## **M25 junction 28 improvement scheme**

### **9.77 Applicant's response to TfL's written summary of hearings**

<b>Rule Number:</b>	Rule 8(k)
<b>Planning Inspectorate Scheme Reference:</b>	TR010029
<b>Application Document Reference:</b>	TR010029/EXAM/9.77
<b>Author:</b>	M25 junction 28 scheme, Project Team, Highways England

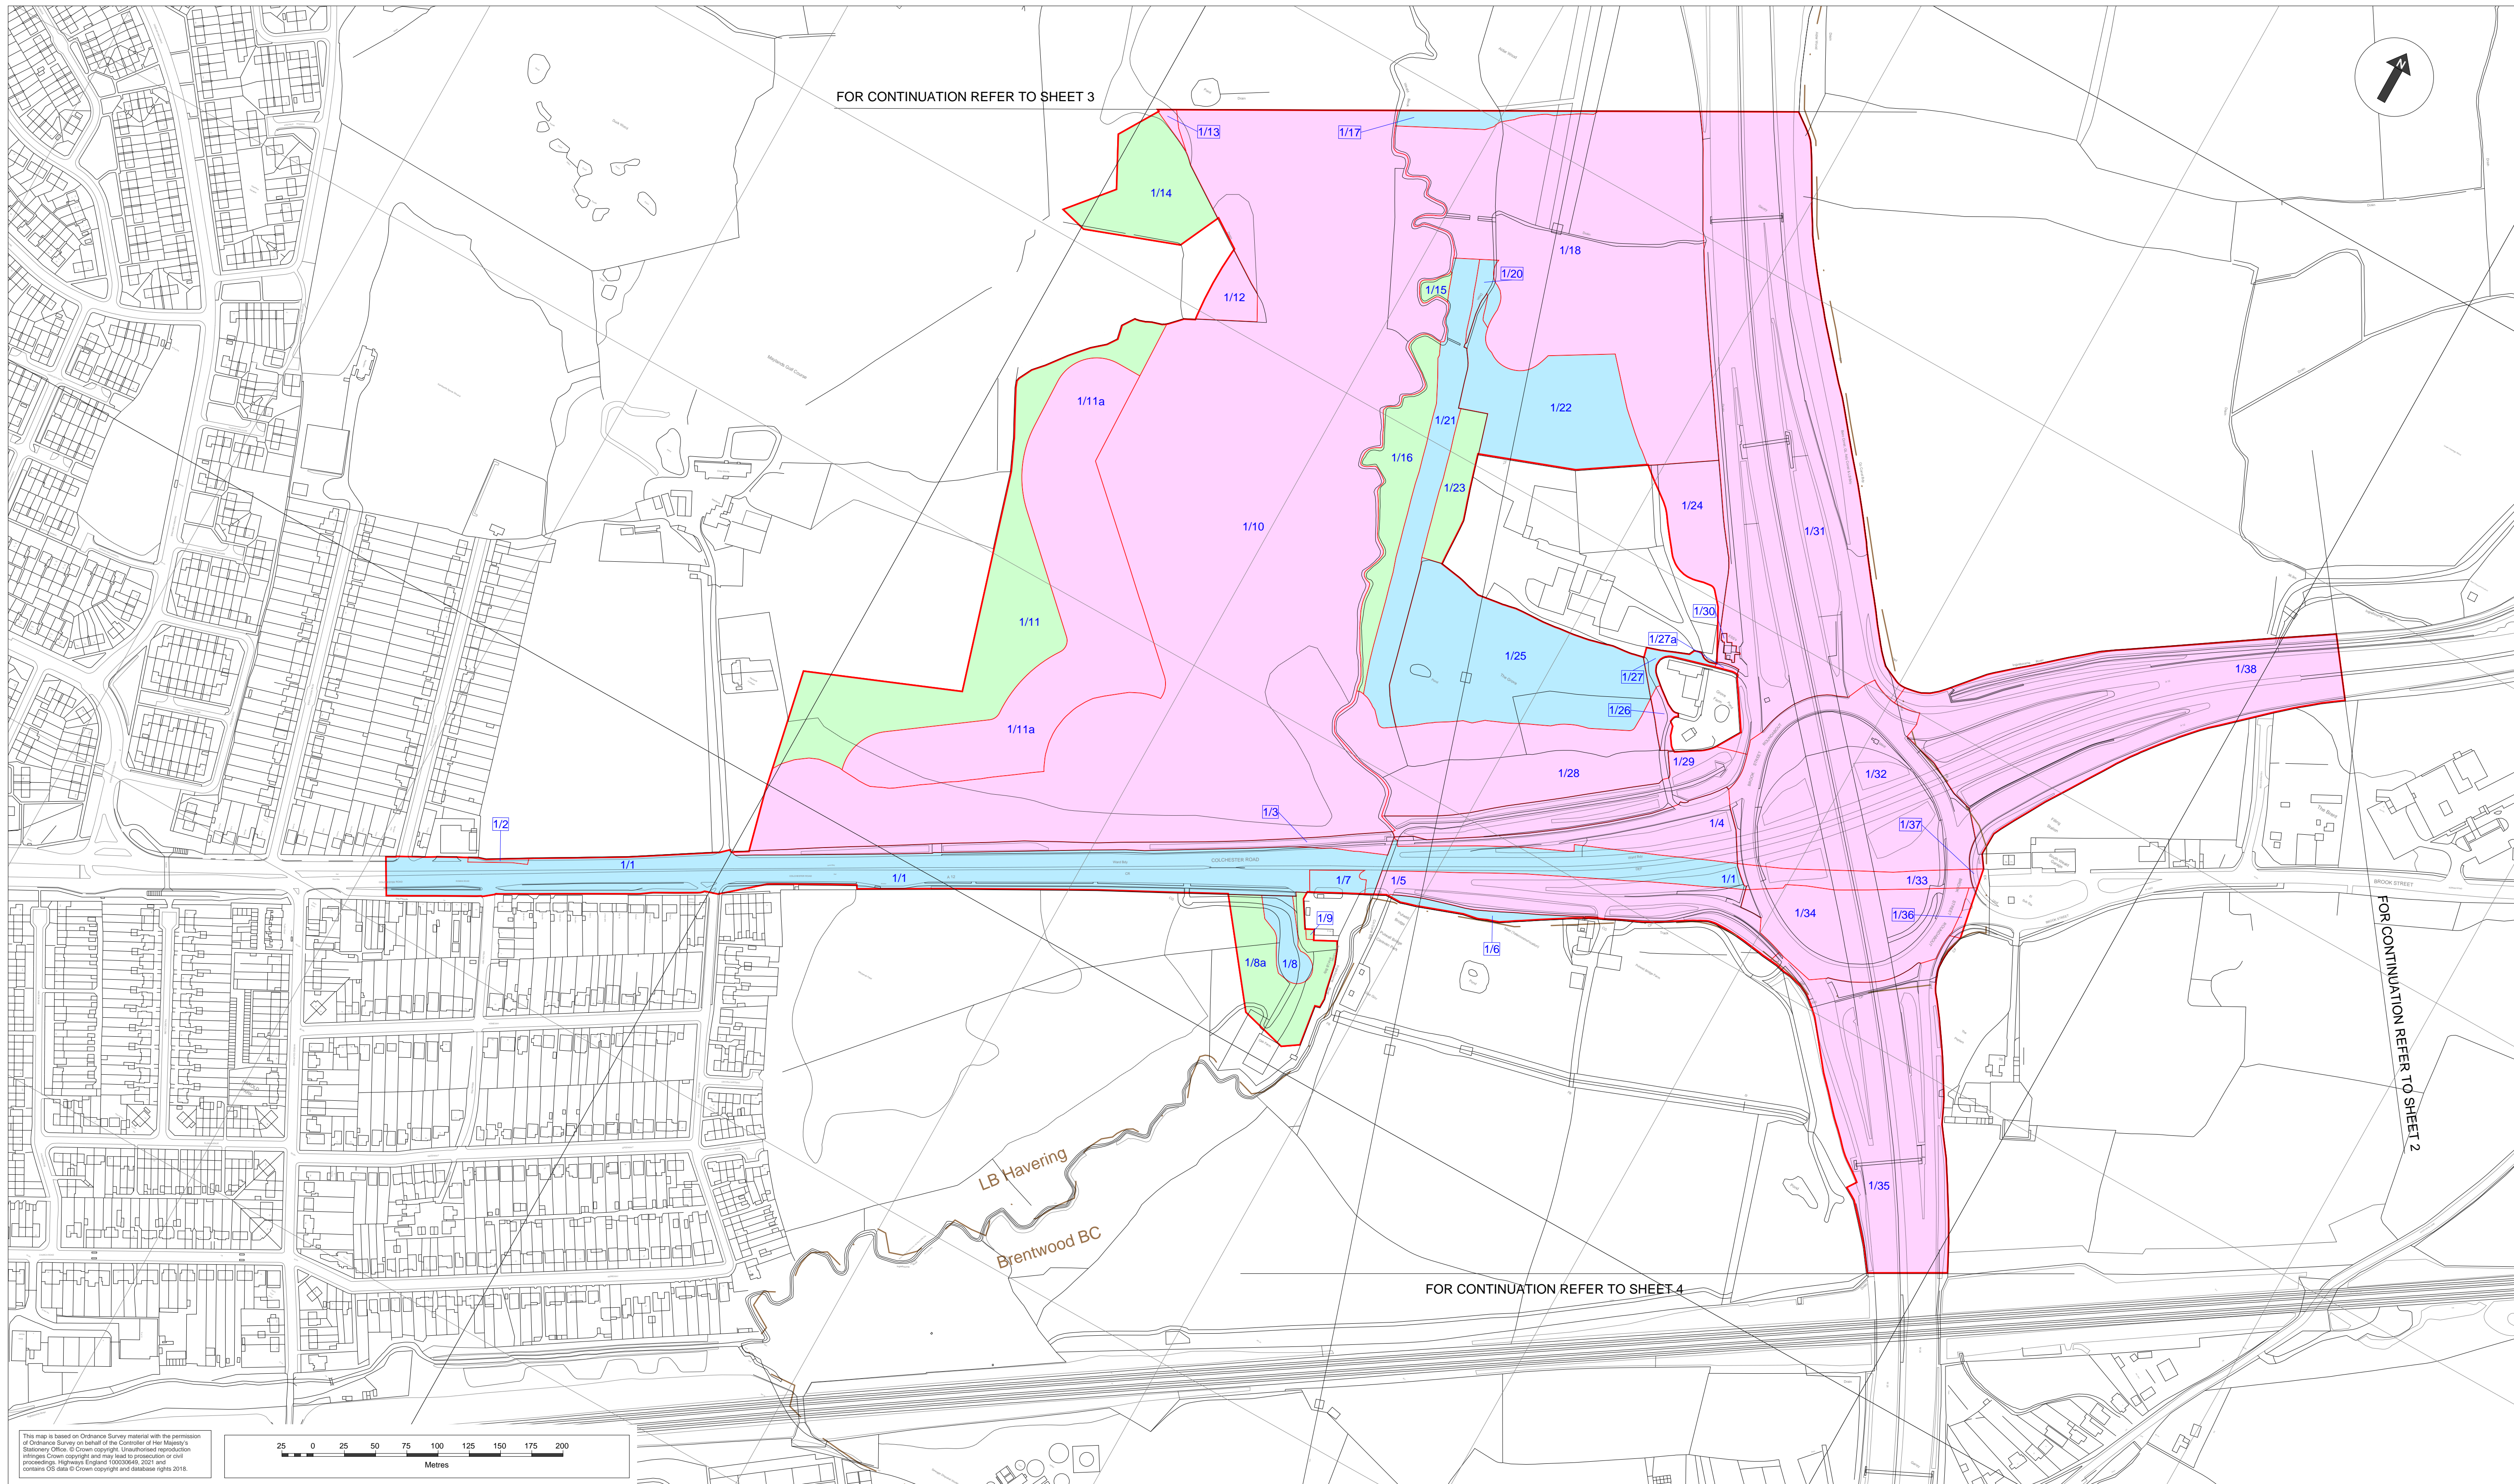
Response reference:	Representation Issue	Highways England Response
REP4-038-06	<p><b>Plot 1/1</b></p> <p>TfL stated at the hearing that it was pleased to see that plot 1/1 has now been split into several plots reducing the nature of the rights being sought over plots 1/1, 1/1b, 1/1c and 1/1d, however concern remains over the extent of the permanent rights sought in plot 1/1a and why the plot and the rights sought extend for such a length of the A12 eastbound carriageway. As TfL is the highway authority here and will remain so following completion of the scheme, the only reason TfL was aware of the potential need for the permanent acquisition of rights in this location was in relation to the Cadent Gas diversion (Work No. 29) which affects only a small part of the plot. Even with the Cadent Gas diversion, it is arguable that rights for this, so far as they affect the highway, could be covered by the rights of undertakers under the New Roads and Street Works Act 1991 (NRSWA) which still applies to works required as part of the scheme albeit amended by the draft DCO.</p>	<p>Refer to response REP4-038-07 below and Highways England's response to the TfL Deadline 3b submission (REP4-011).</p>

Response reference:	Representation Issue	Highways England Response
REP4-038-07	<p>Since the Compulsory Acquisition Hearing, TfL has discussed the rights sought further with the Applicant. The Applicant has advised that the permanent rights sought for plot 1/1a relate to utility diversionary works and drainage. However, it remains unclear why the Applicant needs a permanent right for the diversion of utilities within the existing highway and cannot rely on rights secured pursuant to the NRSWA rather than a permanent property right. TfL further requires clarity on whether it is the intention of the Applicant to transfer the benefit of any permanent rights sought to third party utility providers, and if so to which organisations</p>	<p>Highways England has explained to TfL the need for the extent of plot 1/1a. This plot is required not only for the Cadent gas pipeline diversion but also for drainage works associated with the new loop road (Work No. 6) and to divert existing utility apparatus. Whilst the New Roads and Street Works Act 1991 (NRSWA) does still apply (subject to the provisions in article 10 of the dDCO (REP4-009) and adjustment by the London Permit Scheme made under Part 3 of the Traffic Management Act 2004), the dDCO has been drafted to ensure that any diversions required as a result of the Scheme can be delivered with the necessary rights for those undertakers. This is not an uncommon approach in DCOs and gives the statutory undertakers reassurance that they will have rights for their diverted apparatus without the need to secure further permissions.</p> <p>Highways England can confirm that it does intend to transfer the benefit of any permanent rights sought to third party utility providers and has provided TfL with the information it requested.</p>

REP4-038-08	<p>TfL also notes that the draft DCO submitted at Deadline 3a did not include an update to Schedule 6 to cover the split of plot 1/1 and the original wording of the rights required for plot 1/1 does not refer to utility diversions (other than Cadent Gas) or to rights relating to drainage. The schedules to the DCO need to be updated to reflect</p>	<p>The draft DCO submitted at Deadline 4 (REP4-009) does include updates to Schedule 6 and Schedule 8 (as regards temporary possession rights sought) to reflect the discussions to date with TfL. The amendments are shown on the revised land plan (sheet 1) submitted as part of document REP4-019.</p>
